Drainage engineer comments

Subject: Re: AL/20/21/PL - Wings Nursery, Lindsey Road, Woodgate (Private and Confidential)

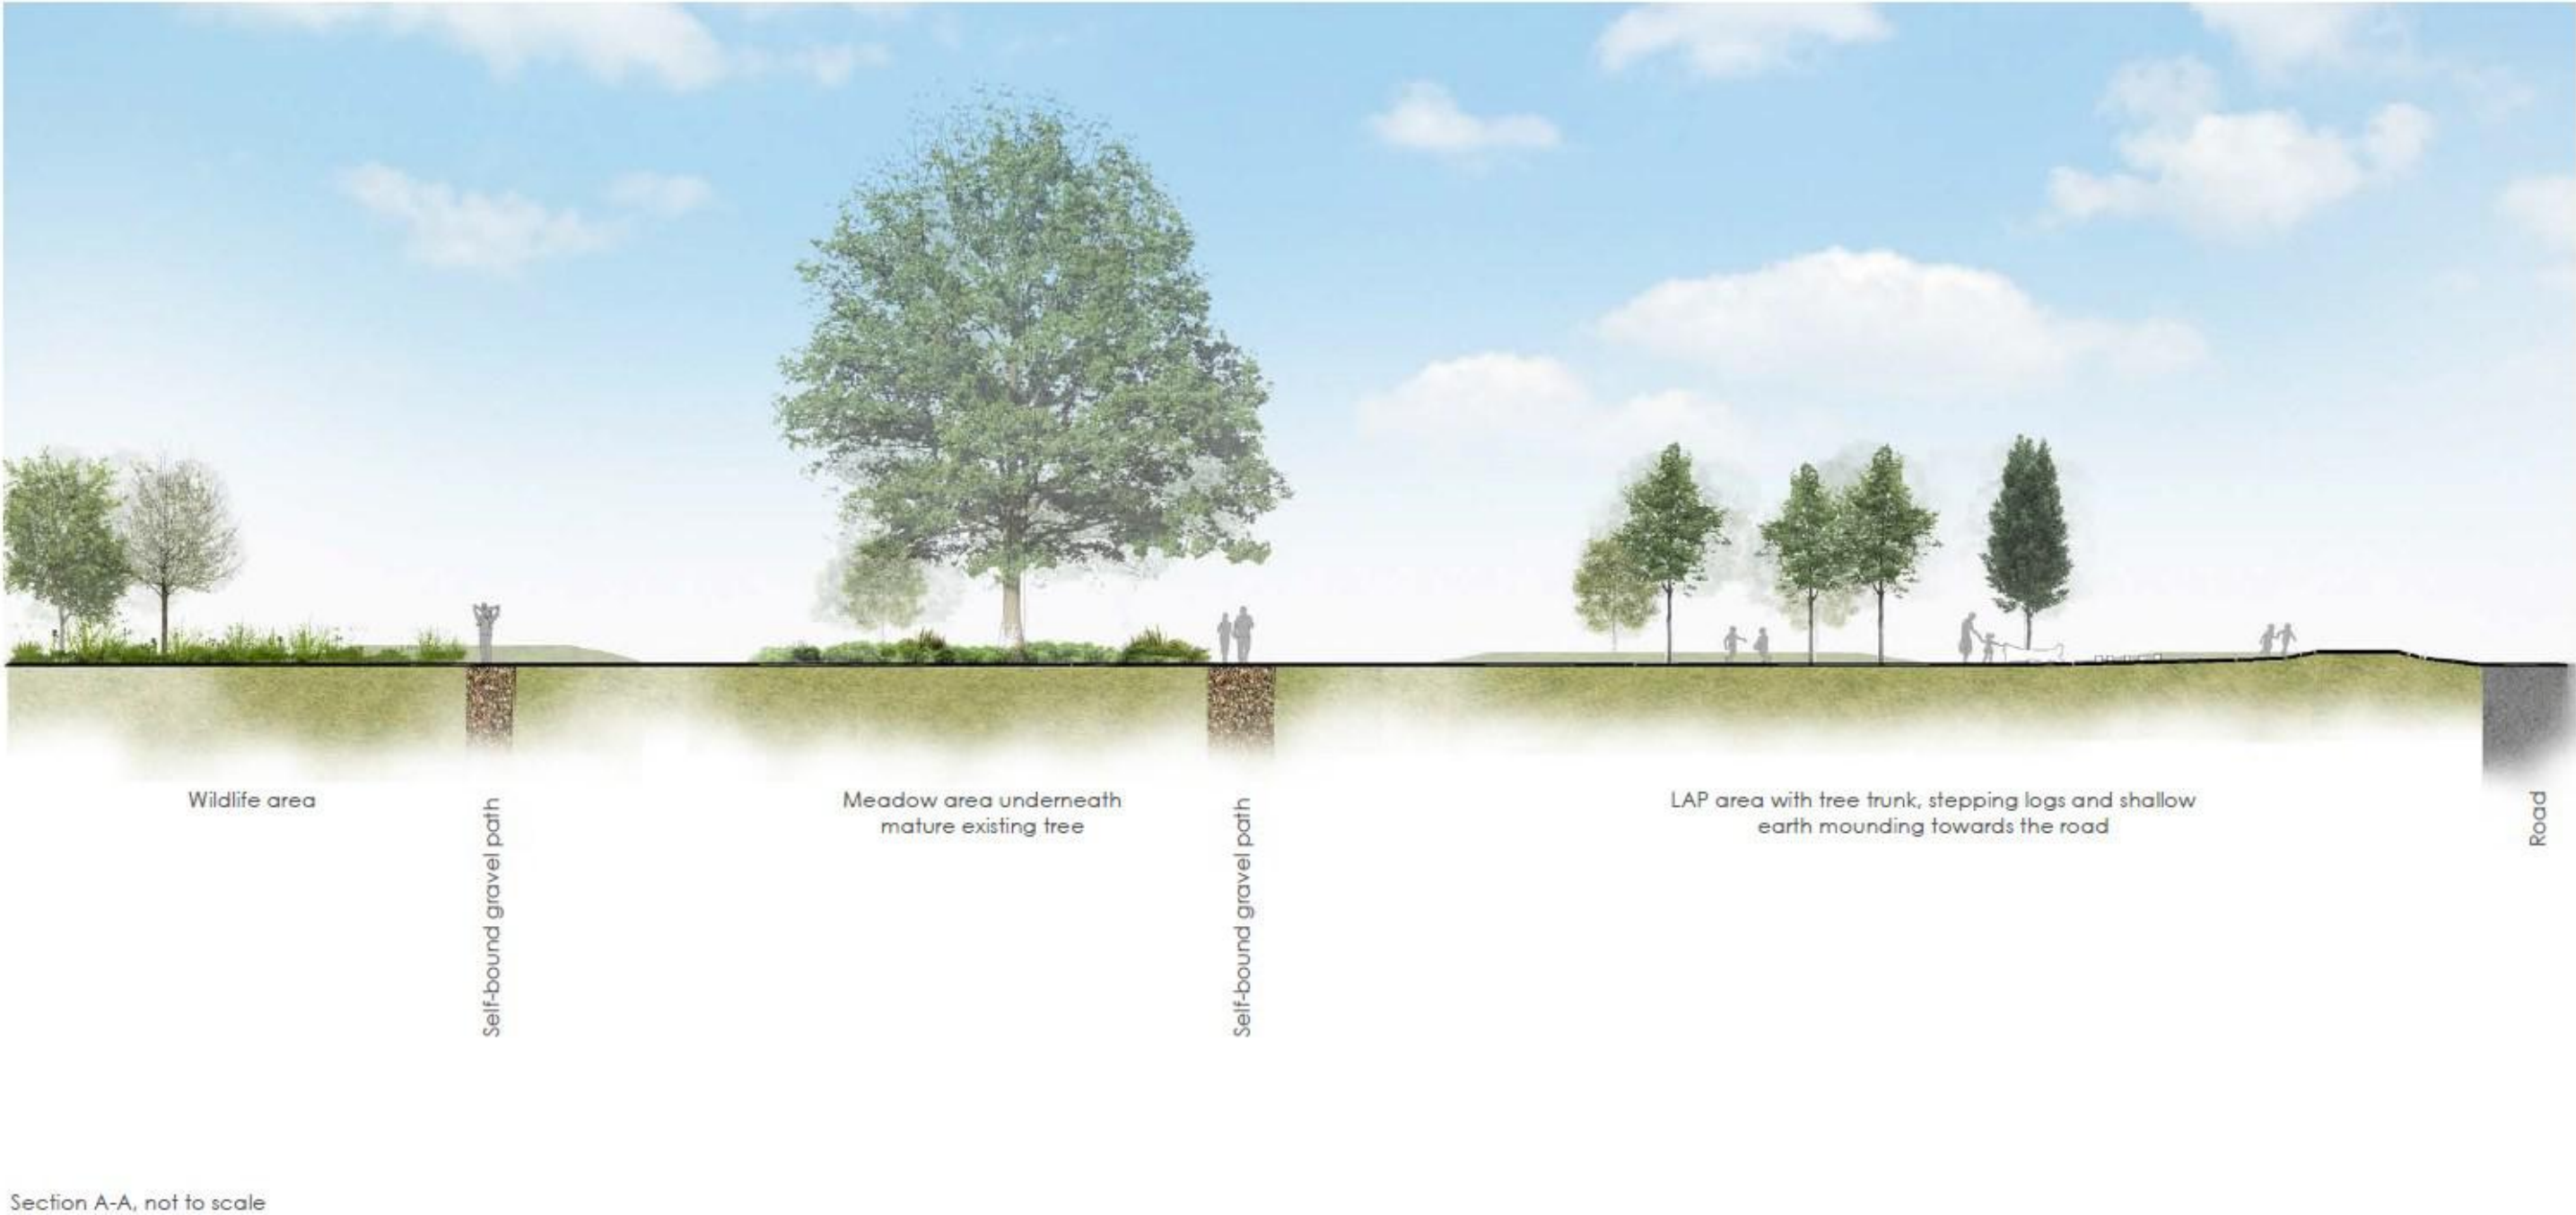
I have reviewed the revised landscaping proposals. The root potential areas of trees have not been provided on plans. However, it can be seen that proposed trees are still in very close proximity to both the attenuation basin and attenuation tank. Due to high groundwater levels on site it is vitally important to the functioning of the drainage system that impermeable liners are not damaged by tree roots. I would therefore request that the landscaping and drainage plans are not listed as approved as these will need to be further changed.

Please find attached the amended landscape plans which have removed the trees from the attenuation basin as requested.
